**Comments on the Applicant's 'Without Prejudice'
Derogation Case
for the
Royal Society for the Protection of Birds**

**Submitted for Deadline 4
13 December 2021**

**Application by Alternative Use Boston Projects Limited for an
Order Granting Development Consent for the
Boston Alternative Energy Facility**

**Planning Inspectorate Ref: EN010095
Registration Identification Ref: 20028367**

Figure 3-1 Possible Locations of compensation options

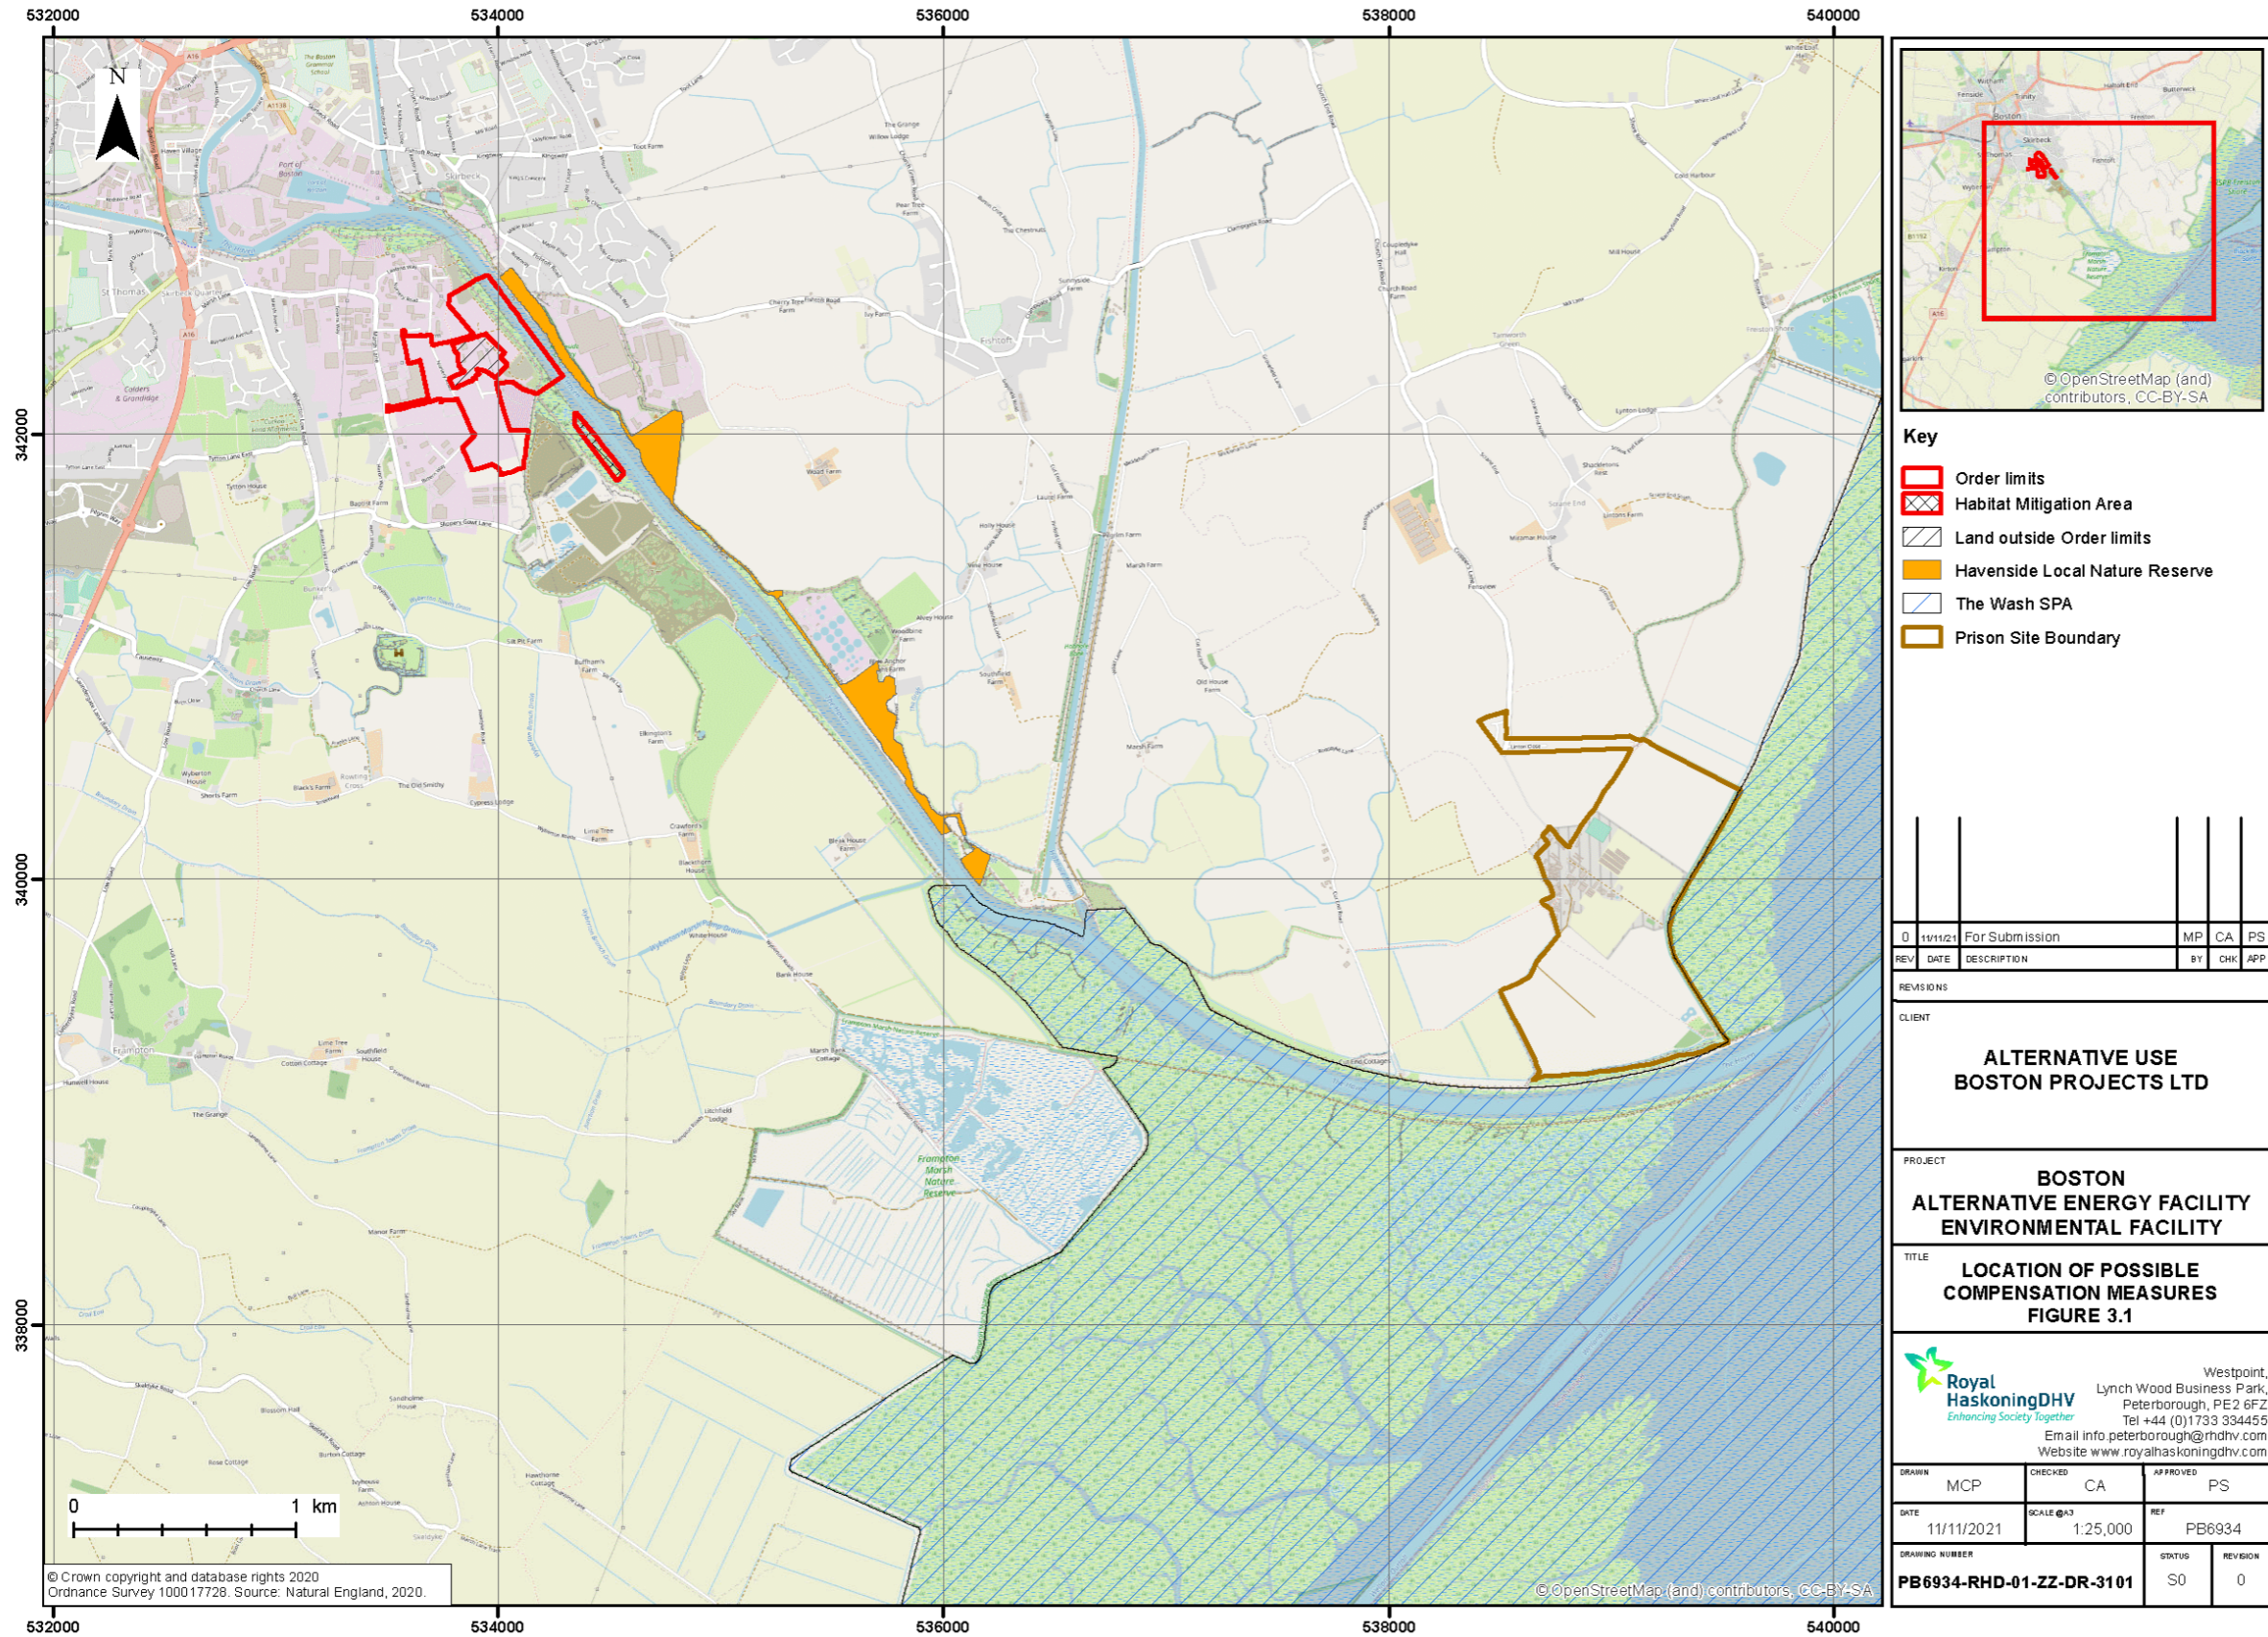
Option	Description	Location relative to SPA	Objective for compensation site	RSPB comments
1	Habitat management of areas within the prison boundary to encourage birds to use the area in line with the Prisons objectives.	North Sea Camp Prison Boston	To provide foraging and bathing habitat for SPA populations of Dark bellied Brent Geese and Black-Tailed Godwit. Also could provide potential roosting habitat for redshank, oystercatcher, lapwing and golden plover.	<p>The creation of a lagoon could provide an alternative location for dark-bellied brent geese to bathe. The provision of freshwater for bathing would be preferred by this species, but a saline lagoon would likely still be attractive to the species for bathing. A lagoon could work well for roosting redshanks and other species, providing it is large enough, undisturbed and likely has unvegetated or sparsely vegetated islands or very shallow water.</p> <p>However, dark-bellied brent geese are one of a few species that already make good use of the prison fields near The Haven mouth. They feed on the rye grass sward provided for sheep grazing on the fields owned by HMP North Sea Camp (based on direct observations from RSPB reserve staff). The creation of a lagoon on these fields could therefore result in foraging habitat <u>loss</u> for dark-bellied brent geese and could reduce their overall use of the site i.e. it could have an adverse effect on this functionally linked land to The Wash SPA/Ramsar site.</p> <p>The fields also offer potential feeding areas for black-tailed godwit, curlew, ruff and other species. The creation of a lagoon on these fields could therefore result in foraging habitat loss for black-tailed godwit, curlew, ruff and other waterbirds.</p> <p>The above highlights the importance on having clarity on the scale of ecological impacts, the number of birds that need to be accommodated and ensuring that a baseline ecological understanding of any proposed options is developed to determine whether a suggested site would be appropriate.</p> <p>In addition, it is important to understand whether management of the land as a lagoon for roosting would be “...in line with the prison’s objectives.” This information is needed to understand the viability of the</p>

Option	Description	Location relative to SPA	Objective for compensation site	RSPB comments
				<p>option and the scale of compensation that could be delivered, as the prison's objectives may make it difficult or impossible to deliver the required ecological objectives for the affected features of The Wash SPA/Ramsar. This issue will need to be evaluated before this option is pursued further.</p> <p>Whilst the principles being developed for this option could be appropriate, the Applicant must also explore options for other adjacent land that could deliver the same ecological requirements, but on sites that would not conflict with current waterbird activity.</p>
2	Habitat reinstatement of overgrown freshwater habitat within the Havenside LNR. Pools located around the monument are in need of clearing to open up the habitat.	Havenside LNR	To provide additional habitat for waders and wildfowl. The distance from the footpath would need to be maximised. As it is within the LNR it is expected that dogs would be kept on leads and therefore disturbance minimised.	<p>Whilst this option could deliver some small Biodiversity Net Gain by improving the quality of the wetland features within the Havenside LNR for aquatic plants and amphibians this is not going to deliver any meaningful habitat improvements for waders and wildfowl due to the very small size, high disturbance caused by proximity to walkers, dogs (whether on a lead or not) and presence of mature hedgerows.</p> <p>This highlights the need to have clarity on measures that constitute compensation separately from the measures that will deliver environmental net gains.</p> <p>We do not consider this a suitable compensation option based on our experience of habitat creation for waders and wildfowl.</p> <p>Again, this option further highlights the importance on having clarity on the scale of ecological impacts, the number of and type of birds that need to be accommodated and ensuring that a baseline ecological understanding of any proposed options is developed to determine whether a suggested site would be appropriate.</p>

3	Potential for habitat creation alongside The Haven on the north bank within the Havenside LNR.	Havenside LNR	As above	<p>The Havenside LNR appears to be unsuitable for the creation of additional wetland habitat for waterbirds due to:</p> <ul style="list-style-type: none"> • Its insufficient size; • It is too linear to allow appropriate habitat to be developed free from disturbance;

Option	Description	Location relative to SPA	Objective for compensation site	RSPB comments
				<ul style="list-style-type: none"> • Disturbance by walkers, dogs and other activities already occurs; and, • Mature hedgerows that affect sightlines for birds scanning for predators and will actively avoid such sites. <p>All these factors make any habitat created unlikely to be successful.</p> <p>We acknowledge that the largest block (of 4ha) is a broader, triangular shape rather than the thin linear patch of scrub/meadow regularly used by visitors. This has more potential, but is still unlikely to be large enough to support waders and wildfowl. It would also represent a loss of scrub in the area, which is an important habitat in its own right and is limited within The Haven area.</p> <p>Again, this option further highlights the importance on having clarity on the scale of ecological impacts, the number of birds that need to be accommodated and ensuring that a baseline ecological understanding of any proposed options is developed to determine whether a suggested site would be appropriate.</p>

4	<p>Provision of artificial wader roosting habitat within the SPA. This could potentially involve the placement of rocks alongside existing rocks that have been placed on the shallow intertidal area within the SPA or provision of floating roosting sites.</p>	<p>Within the SPA but far enough away from the vessel transit routes to ensure minimal or no disturbance.</p>	<p>To provide additional habitat, rocks would provide habitat particularly for black-tailed godwit, turnstone, oystercatcher and redshank.</p> <p>Although this option could meet the objectives for the birds within the SPA it would reduce the area of intertidal mudflat within The Wash and North Norfolk SAC which could compromise the</p>	<p>As identified by the Applicant, any proposed options within The Wash would impact on habitat and species features. Any such option would destroy existing SPA/SAC/Ramsar habitat and necessitate compensation as a result of this proposed option. Therefore, we do not consider this option to be compatible with the Habitats Regulations tests and the underlying purpose of those Regulations, as it would result in adverse impacts in its own right. We repeat our previous advice to the Applicant that this option should not be taken forward for this reason.</p> <p>Without prejudice to our fundamental position on this option, we are also concerned that the proposed option identifies black-tailed godwit as a species that could benefit from such measures. They are using the highest areas of mudflat adjacent to The Haven mouth rather than the rocks. This</p>

Option	Description	Location relative to SPA	Objective for compensation site	RSPB comments
			<p>conservation objectives for this site. This would need to be assessed in terms of the potential impacts on the designated sites.</p>	<p>option would therefore not be a suitable alternative option for roosting black-tailed godwits.</p> <p>Irrespective of the inappropriateness of the measures being proposed within The Wash SPA/Ramsar boundary, we do not consider novel approaches such as floating roosting sites to be appropriate, as their effectiveness is unknown and there would likely be navigational risks. They are inherently unproven and therefore should not be pursued.</p> <p>We do not agree that this option is viable and so it should not be progressed any further.</p>
5	<p>Potential for creation of shallow scrapes within agricultural fields although it is recognised that these would be further in from The Haven and may not be suitable.</p>	<p>Approximately 1km from The Haven.</p>	<p>Low potential to provide habitat as relatively distant from The Haven. Potential for habitat for redshank, lapwing and golden plover.</p>	<p>We agree with the Applicant's assessment that there is a low confidence that this option would be successful due to the distance from The Haven and the indication that agricultural operations would be continued. This is particularly the case for lapwings and golden plovers that will prefer larger areas. It is even less likely to be successful for redshanks which typically do not roost far from the intertidal habitat and would likely require islands surrounded by water, such as a lagoon with an island.</p> <p>We note that no specific locations for this option have been identified on Figure 3-1 of document REP2-013.</p> <p>It is not clear why fields closer to The Haven are not being considered as an option. If a suitably large area (consisting of several fields) were secured that could deliver lagoon creation and potentially foraging habitat this might be a more appropriate option. However, this would still require a suitable ecological baseline to be established and clear objectives set for the purpose of the proposed option.</p>

6	<p>Potential for measures to reduce predation risk</p>	<p>Fields alongside The Haven.</p>	<p>Could assist with reduction of predation risk.</p>	<p>We are concerned by this proposed option, as:</p> <ul style="list-style-type: none"> No specific areas have been identified for management.

Option	Description	Location relative to SPA	Objective for compensation site	RSPB comments
	to shorebirds. i.e. Vegetation management.			<ul style="list-style-type: none"> • No details on the type of vegetation management being proposed have been provided. • No detail has been provided on the predators that would be targeted by the activity. • No evidence is presented to demonstrate that predation risk is an issue for waterbirds using The Wash SPA/Ramsar/SSSI. • No evidence is provided to inform the potential ecological impact on other features of The Wash SPA/Ramsar/SSSI and The Wash & North Norfolk Coast SAC, as well as other priority species. <p>This option has been proposed but without any evidence, including from the Applicant’s surveys, that predation risk is currently a significant factor affecting waterbirds using the navigation channel from the application site to the Port of Boston anchorage area. There is also no evidence provided to indicate what predators the Applicant considers to be a problem along The Haven. Understanding whether the predator is, for example, domestic cats, birds of prey, foxes, otters, badgers, stoats or mink (not an exhaustive list), will identify any management measures that would be appropriate to address any problem that may exist. No such information has been provided by the Applicant.</p> <p>We do not consider that this option demonstrates an understanding of waterbird ecology along The Haven. Indeed, no connection is made by the Applicant to demonstrate that predation risk has any relevance to the key issues identified by the data collected by the Applicant that need to be addressed. Any proposed options must seek to reduce disturbance, displacement, and habitat and other ecological function loss associated with the Application. Whilst management of predation risk may be important when considering the location and design of new habitat, the relative importance of predation risk as a key pressure impacting on roosting and foraging waterbirds along The</p>

Option	Description	Location relative to SPA	Objective for compensation site	RSPB comments
				<p>Haven and its approaches must be set in the context of other activities that are causing disturbance. For example, how important is predation risk when compared to disturbance from vessel movements or recreational activities?</p> <p>The Applicant has also not clarified whether this option is proposed to provide benefits for breeding waterbirds, roosting waders, non-breeding wildfowl, or all of these categories. Breeding waterbirds occur away from the Haven and non-breeding waterbirds appear to utilise very specific locations, although there may be more areas of importance but no data are currently available to demonstrate this to be the case.</p> <p>Consequently, we are concerned that this option would not be appropriately targeted and would have little or no compensatory benefits for the qualifying features of The Wash SPA/Ramsar. We consider this option would be better considered as part of Biodiversity Net Gain measures, subject to addressing the criticisms set out above with regard its lack of clear benefit to any species or species group.</p>
